COMMENTS TO PUBLIC NOTICE OF APPLICATION FOR A BUILDING PERMIT TO DEMOLISH EXISTING SINGLE FAMILY RESIDENCE AND REBUILD A 5000 SQ FT SINGLE FAMILY RESIDENCE WITH A 897 SQ FT GARAGE

LOCATION OF PROPERTY: 3036 67th Ave. S.E., Mercer Island, WA 98040

TAX PARCEL NUMBER: 2174501025

TREE RETENTION PLAN
3036 67TH AVENUE SE
SITE PLAN
PARCEL 2174501025
CITY OF MERCER ISLAND WASHINGTON

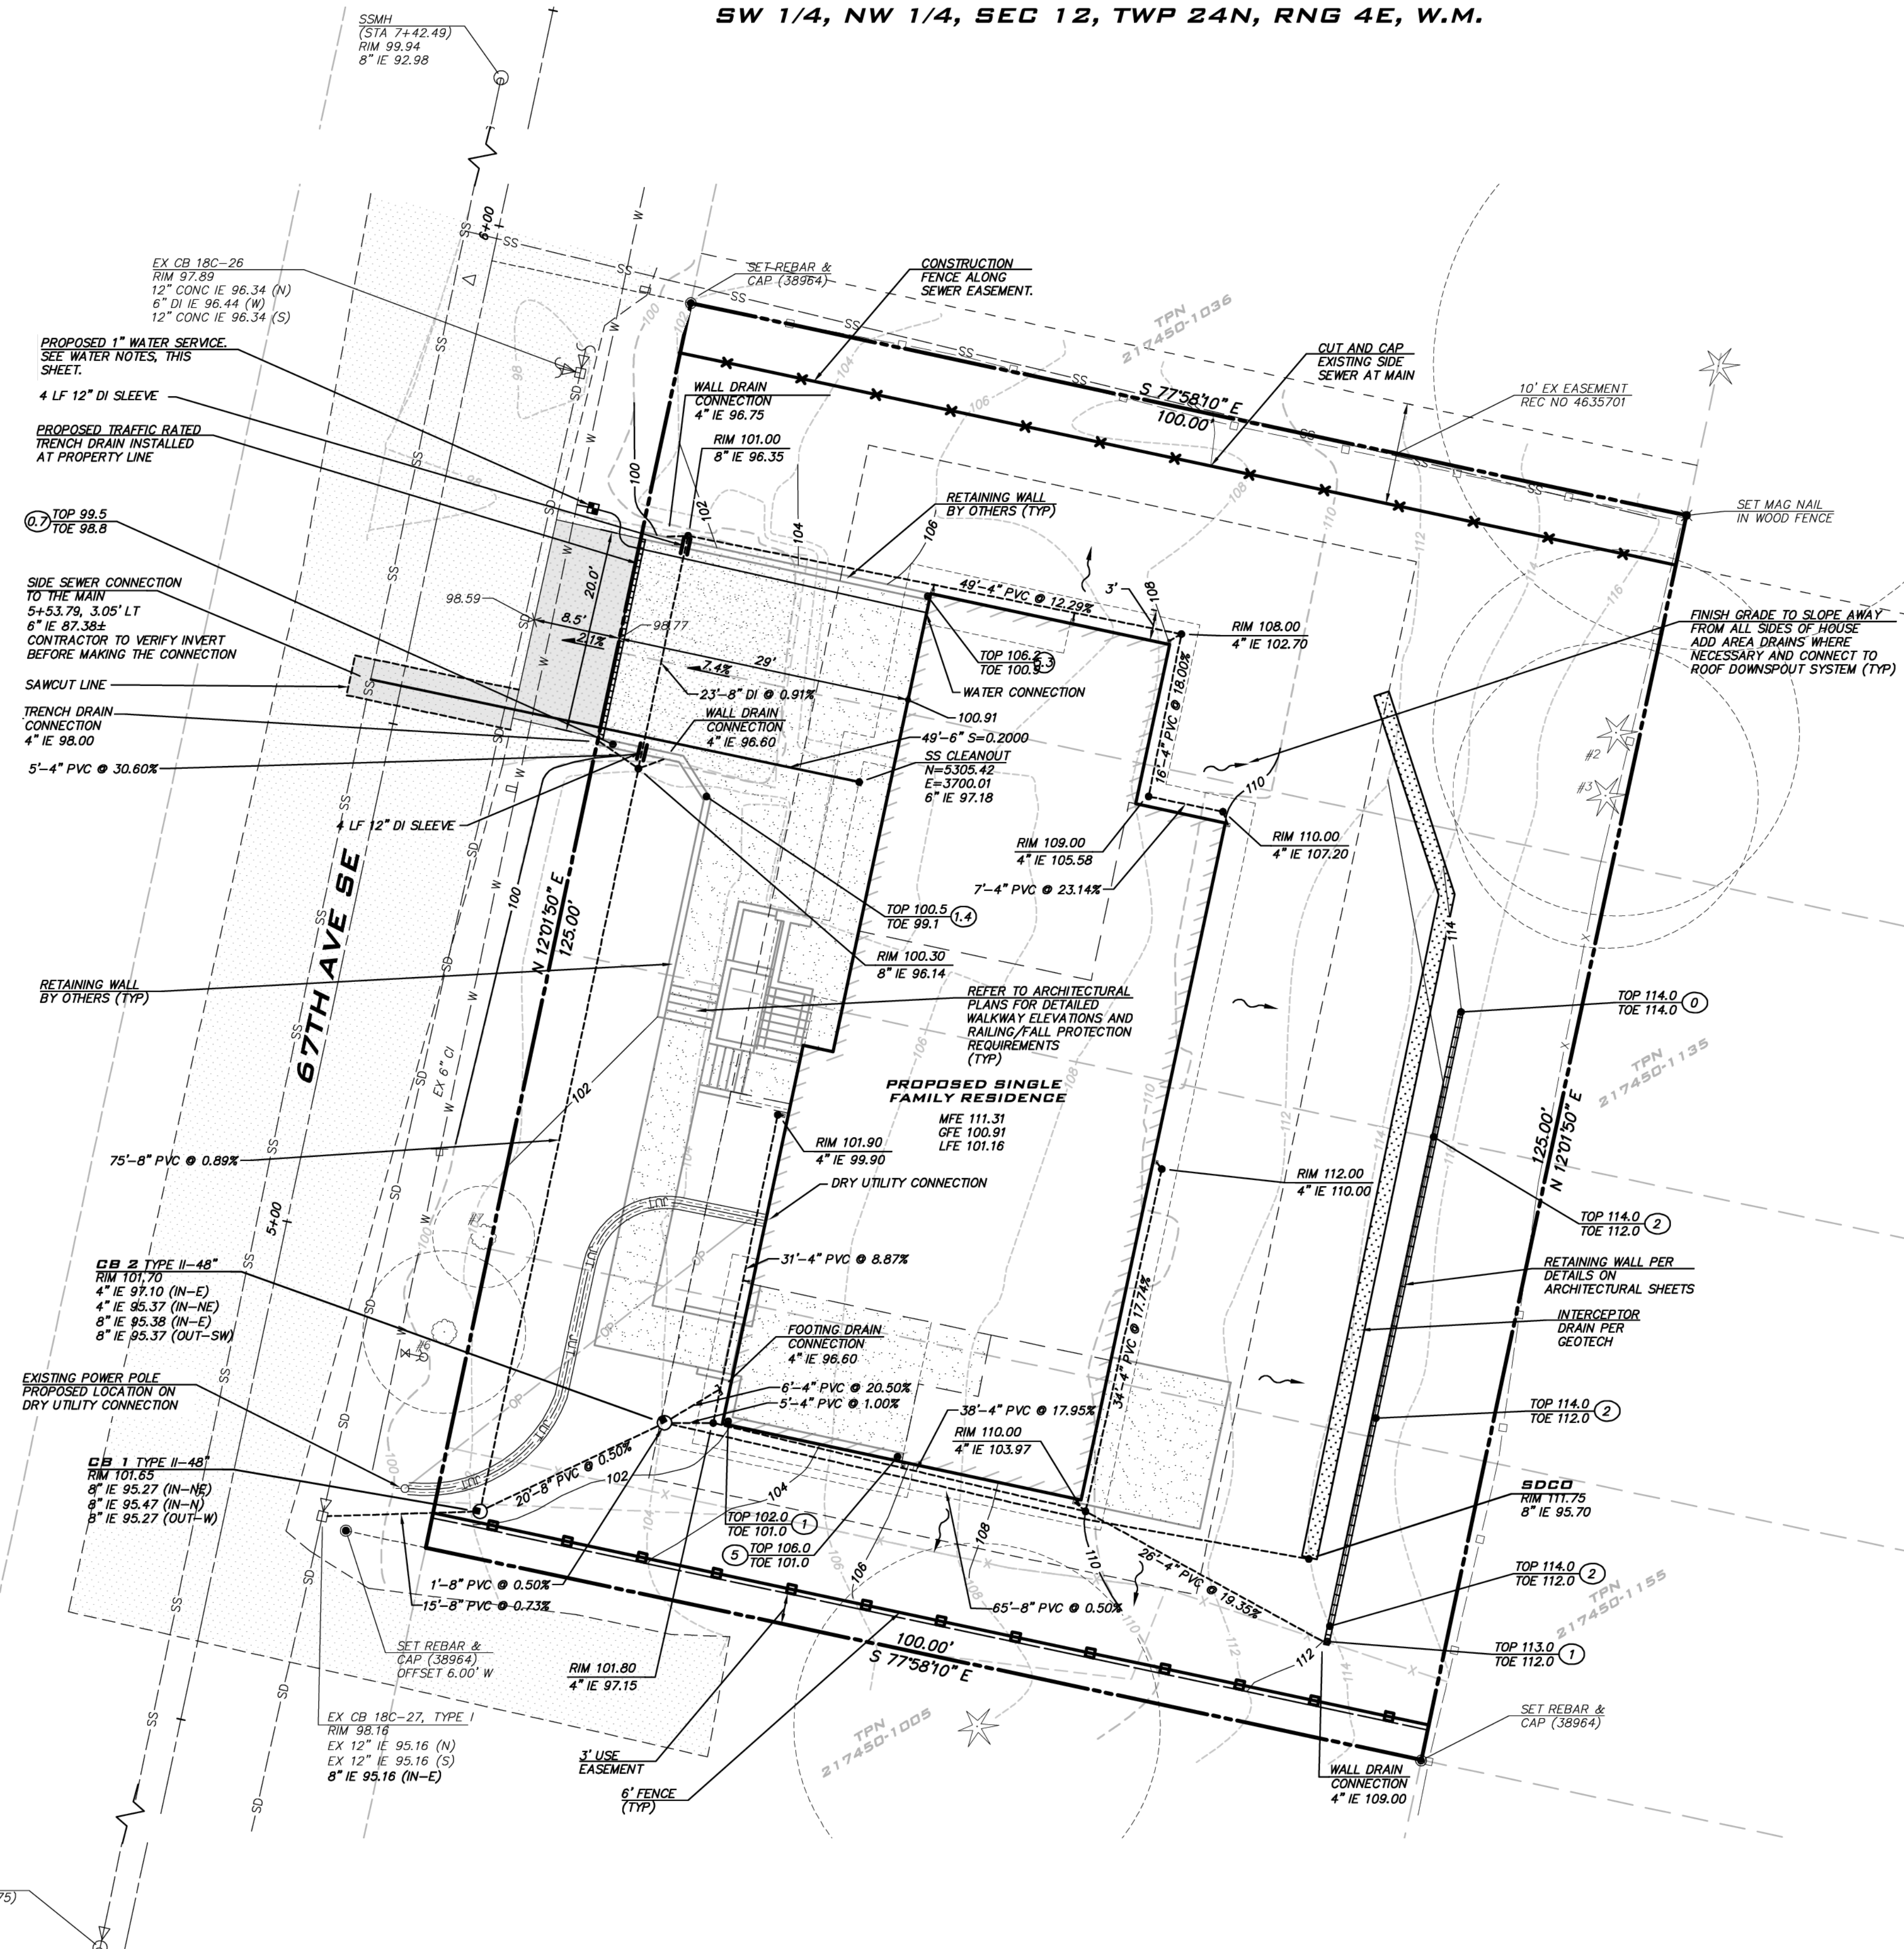
In my separate communications with Matt and Jaime, I expressed my serious concern that Trees 2 & 3 are an extreme hazard to adjoining properties and to 3036 67th Ave SE itself. Past high wind conditions have resulted in a large branch (5" dia. 15-20 ft long) falling onto the property at 3031 68th Ave SE. Multiple attempts to mitigate this problem with the previous property owner have been unsuccessful. Since the last storm with wind gusts exceeding 60 mph, Trees 2 & 3 have had substantial growth on and over the east property line abutting the property at 3031 68th Ave SE.

In discussing the ARBORIST REPORT (dated Oct. 14, 2022) with Jaime B. on Friday, Dec. 16, 2022, he stated he would have the arborist, Tom Quigley, take another look at Trees 2 & 3. Since then a neighbor, Isabella Fu at 3030 68 Ave SE, talked to Jaime Buchan and was told that those limbs, which would be likely to break off in high winds, would be removed. Any work done to mitigate the hazard of falling limbs and even trees need to be in consultation and agreement with the property owner(s) at 3031 68th Ave SE.

Placement of Western Red Cedars, Trees 4-7, at East Property Line, View A1.1

The ultimate growth (as high as 200ft.) of western red cedars, four in total, along the eastern property line, will severely reduce the views of neighboring properties uphill from 3036 67th Ave SE. Property values have been known to be reduced by tens of thousands of dollars by the loss of views. In addition growth of these trees will within 10 years or sooner encroach upon the 3031 68th Ave SE property.

1. Require that Trees 2 & 3 be re-assessed for their potential to produce breakage of large branches and even complete collapse during high wind conditions (exceeding 50 mph).
2. Replace Trees 4 through 7 now designated to be western red cedars (*truja plicata*) with trees of maximum height potential of 30ft.

Ron Malatesta is concerned about his view and both our arborist and the city arborist are not going to allow the removal of trees 2 and 3 to accommodate this. He claims the branches are a hazard and we can clean up the tree a little bit but probably not as much as he would like to see.
